11 April 2019

RJC:KV15-166

**Re: State Significant Development Application: SSD 7693
InterContinental Hotel and Transport House
Response to request for additional information**

ITEM B

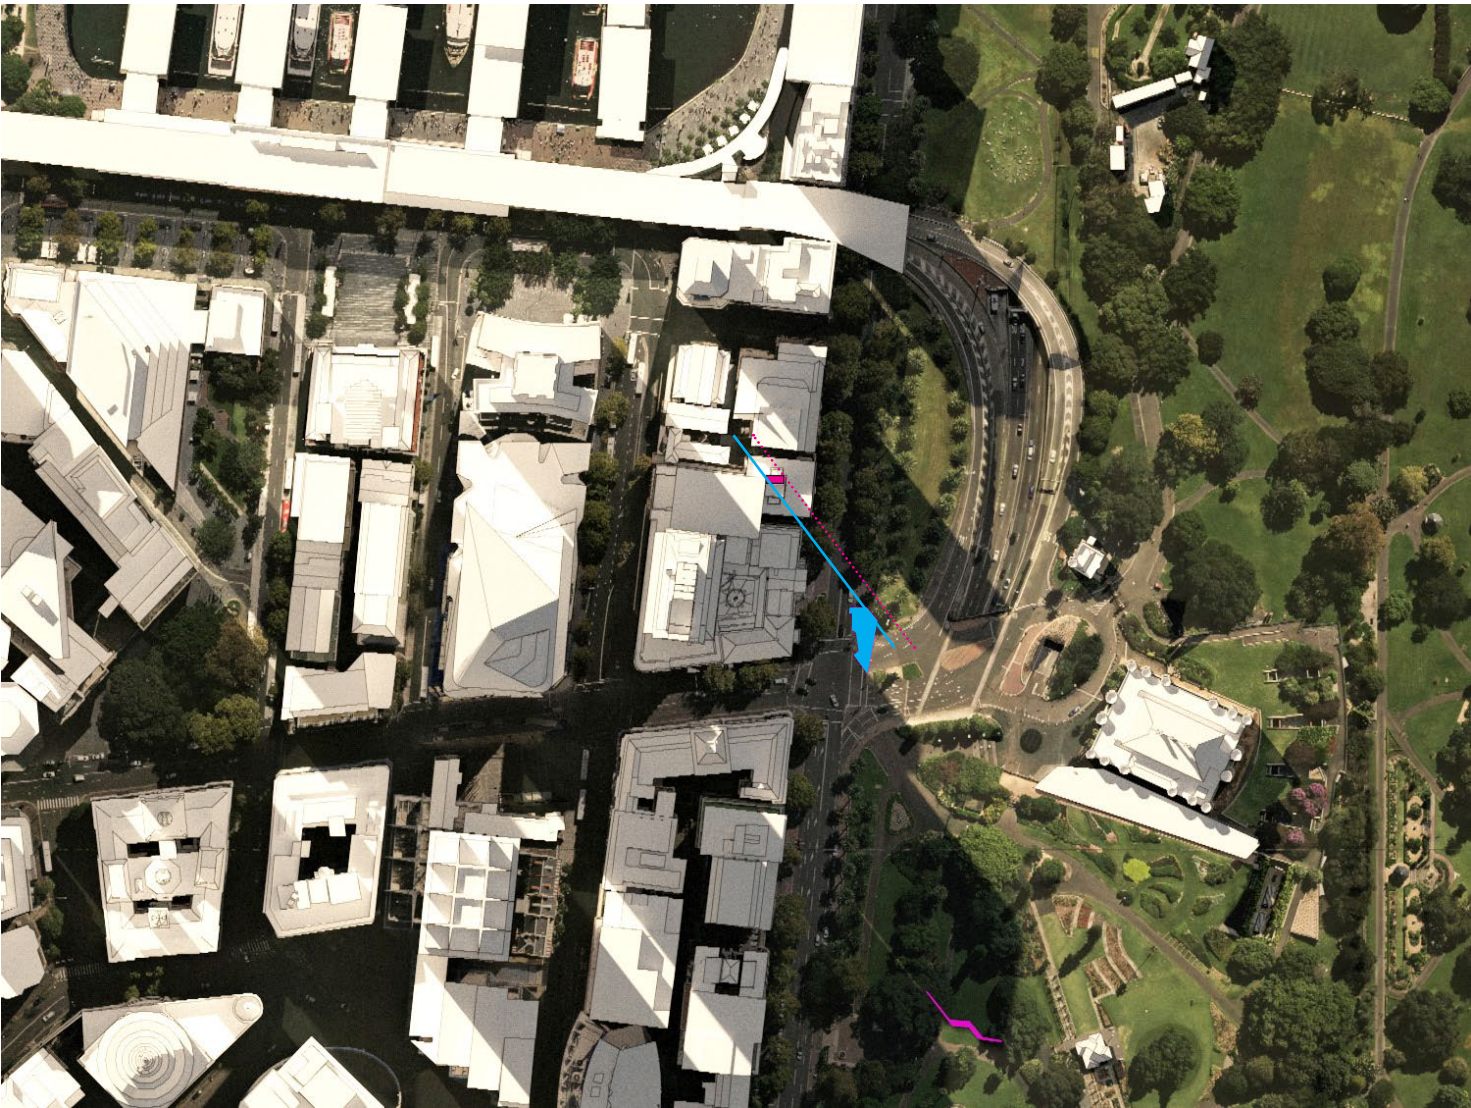
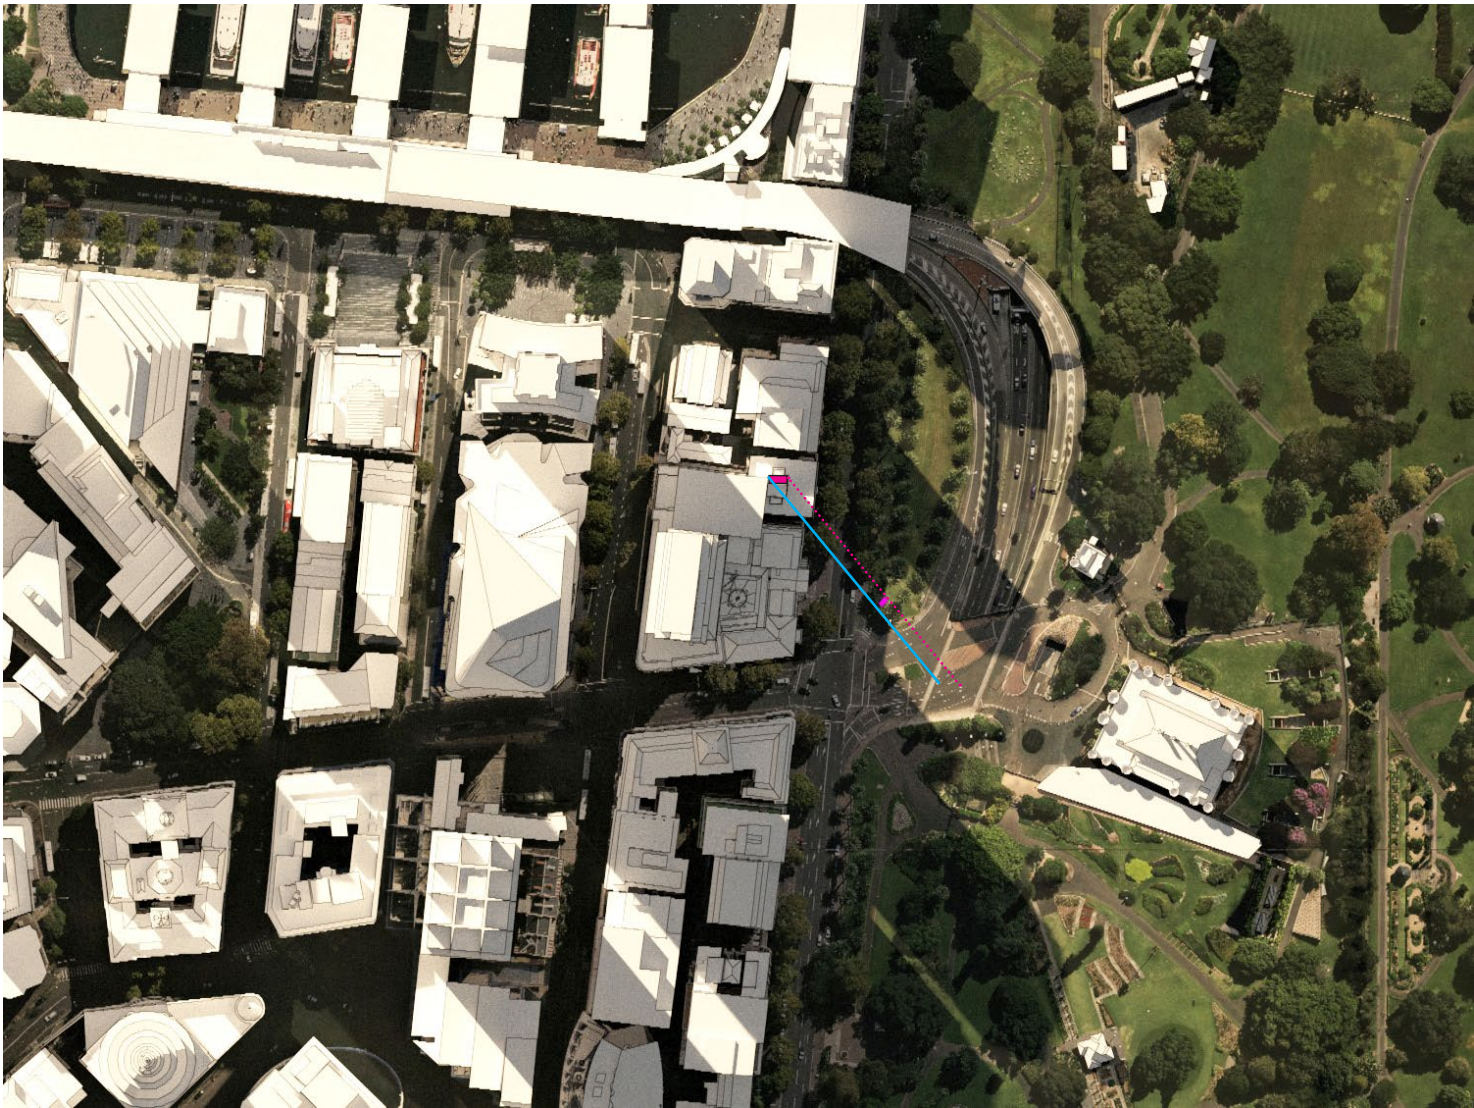
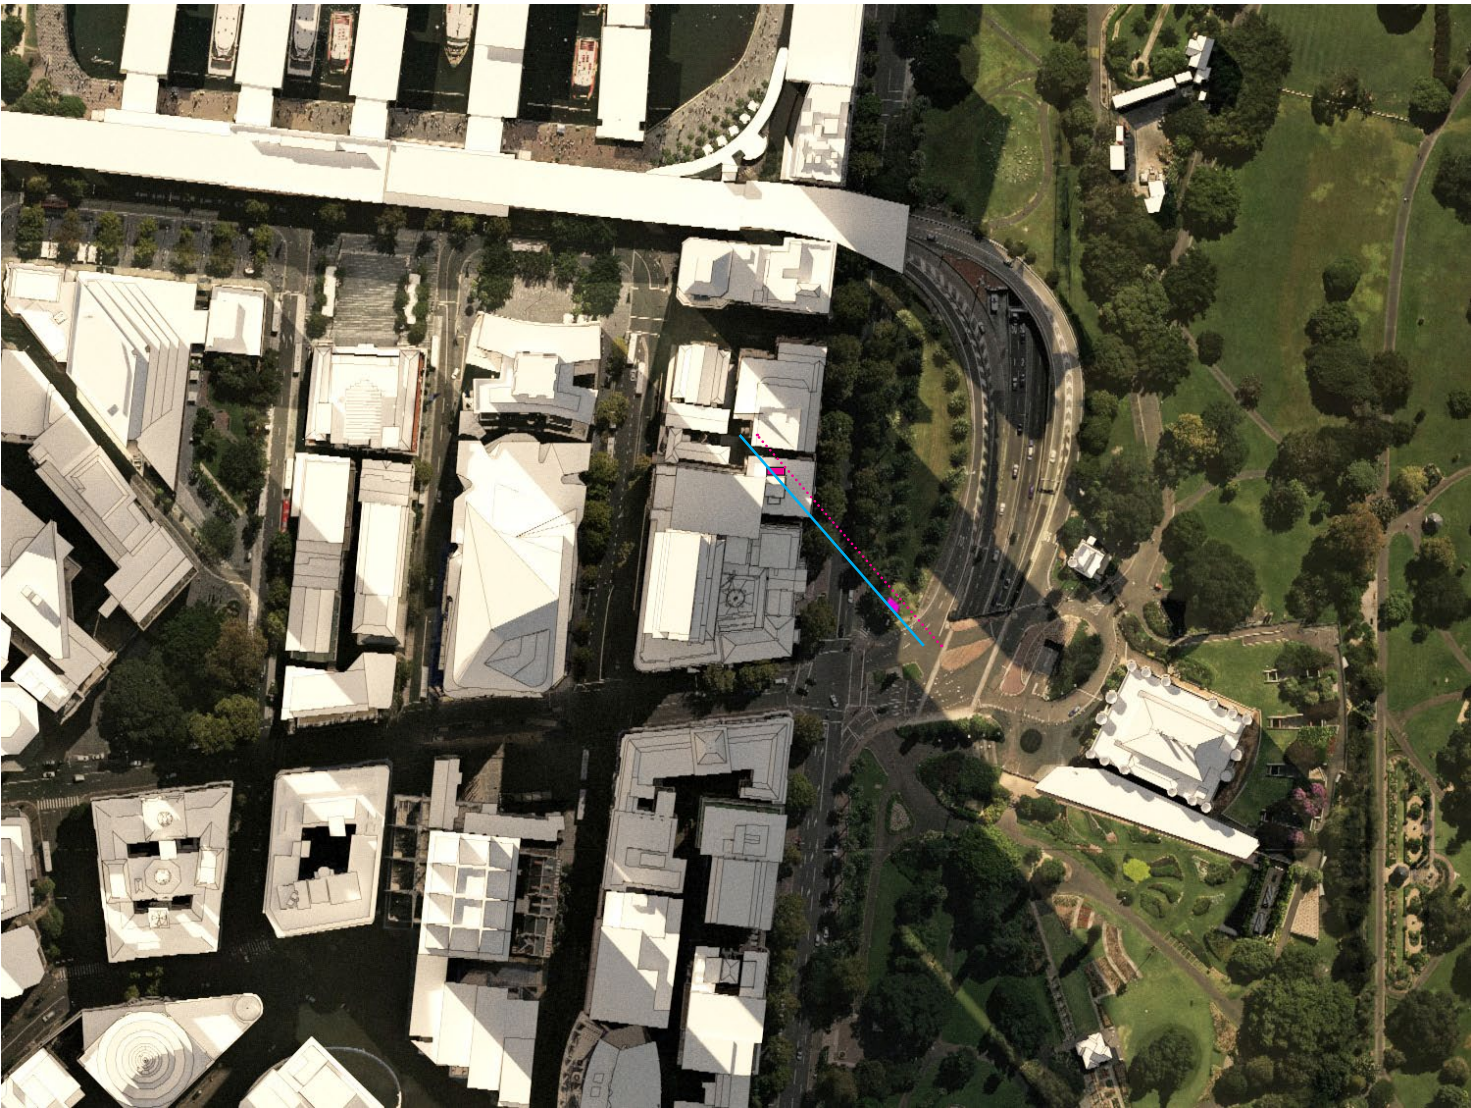
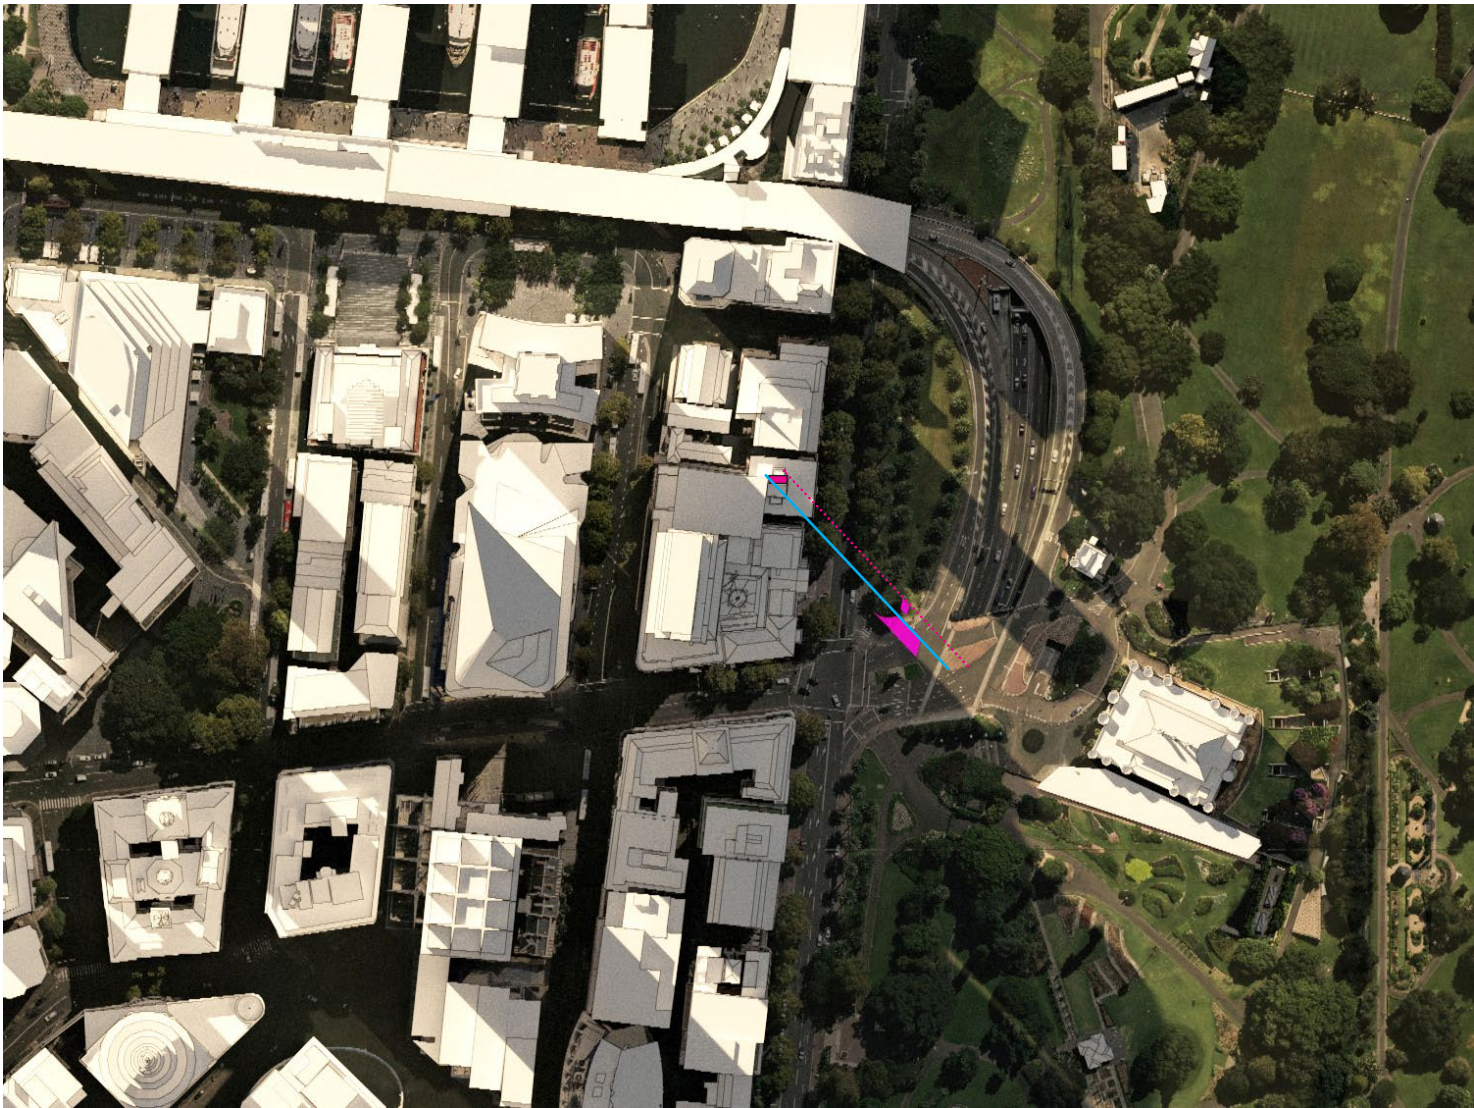
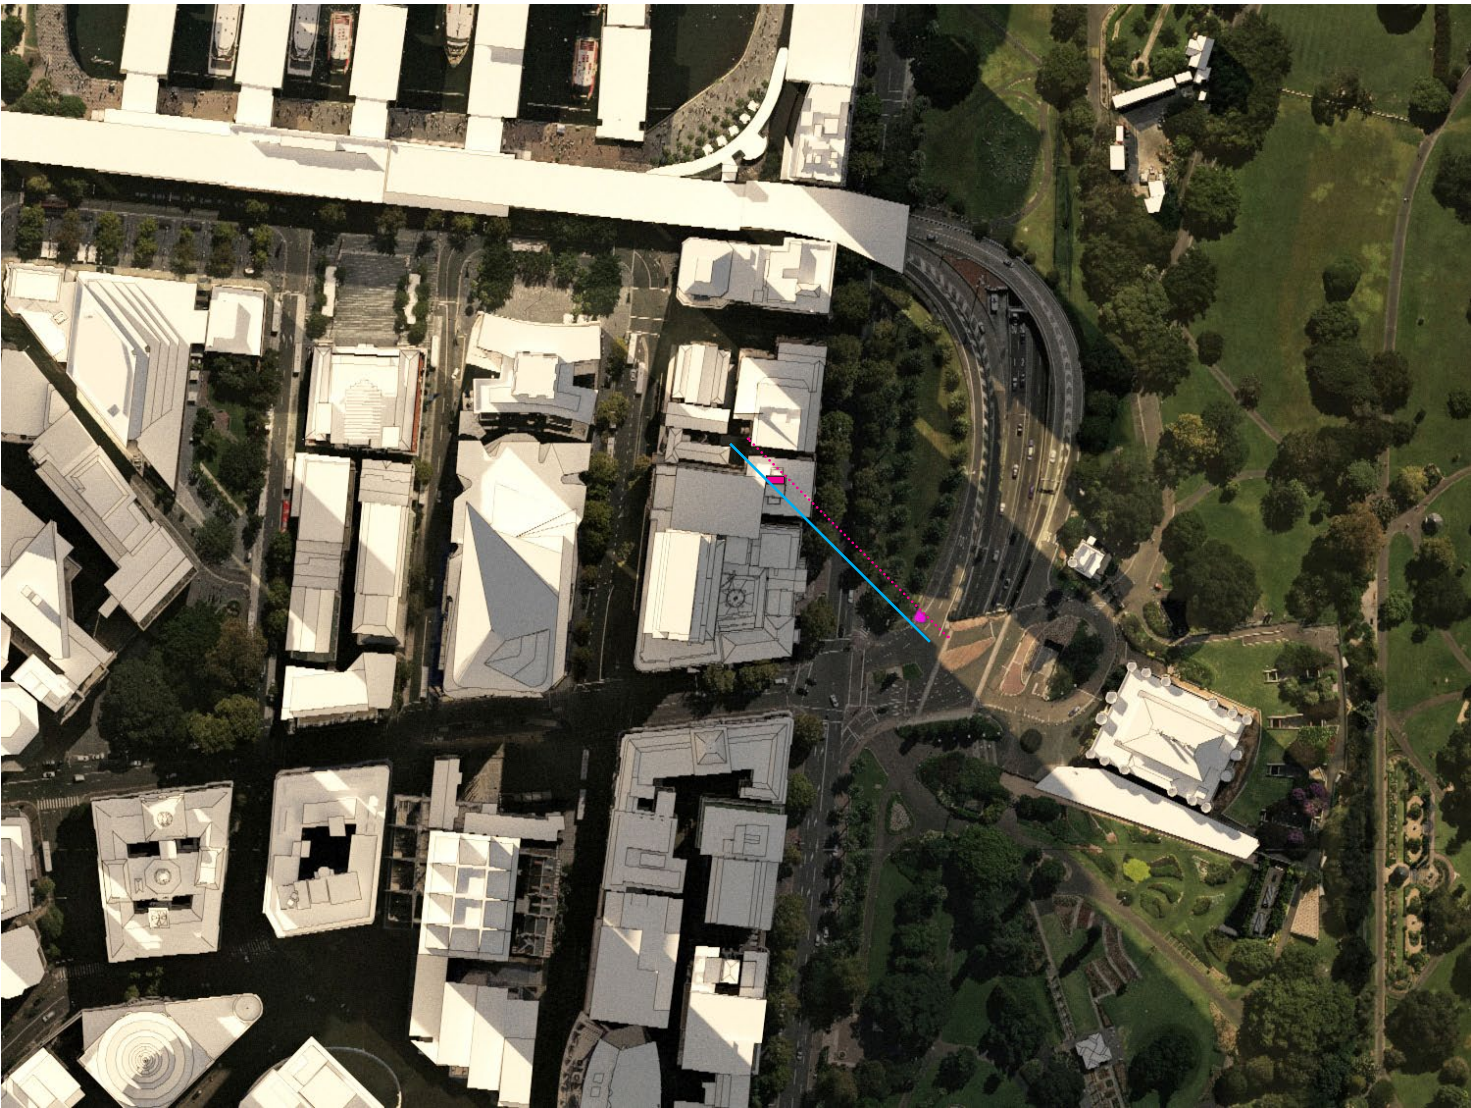
- (b) Shadow diagrams are to be provided in hourly intervals from 9am to 4pm for the winter solstice. In addition, shadow diagrams for half hour intervals are to be provided from 2pm-4pm on winter solstice in order to clearly understand the overshadowing impact to the Royal Botanic Gardens. The extent (i.e. duration and area in m²) of overshadowing to the Royal Botanic Gardens (RBG) shall also be quantified.**

- (c) Clarify how the increase in overshadowing at 3pm (as shown on Drawing No. ST1-DA_808) is attributed solely to the extension of the building envelope over the Transport House lift motor room (described in Section 4.3 of your letter dated 1 March 2019, as replicated below) and not as a result of the overall building envelope over the Transport House.**

In order to further analyse this impact, shadow diagrams have been produced for 10 minute intervals from 2.30pm to 4pm, principally to identify the area of overshadowing as requested by the Department. Drawings titled Solar Analysis – RBG Shadows 2-5 show the location and area extent in square metres of overshadowing for each 10 minute interval. The shadow impact from the emergency egress extension on Transport House is shown in table form overleaf:-

Time	Area of Shadow (m ²)	Location
2.30pm	0m ²	Nil
2.40pm	11m ²	Royal Botanic Gardens
2.50pm	20m ²	Royal Botanic Gardens
3.00pm	12m ²	Royal Botanic Gardens
3.10pm	18m ²	Footpath and road
3.20pm	15m ²	Footpath and road
3.30pm	25m ²	Footpath and road
4.00pm	0m ²	Nil

In summary, this shows that egress extension on Transport House casts a small shadow over The Royal Botanic Gardens site for approximately 30 minutes in mid-winter. The extent of this shadow reaches a maximum area of 20m² at 2.50pm.
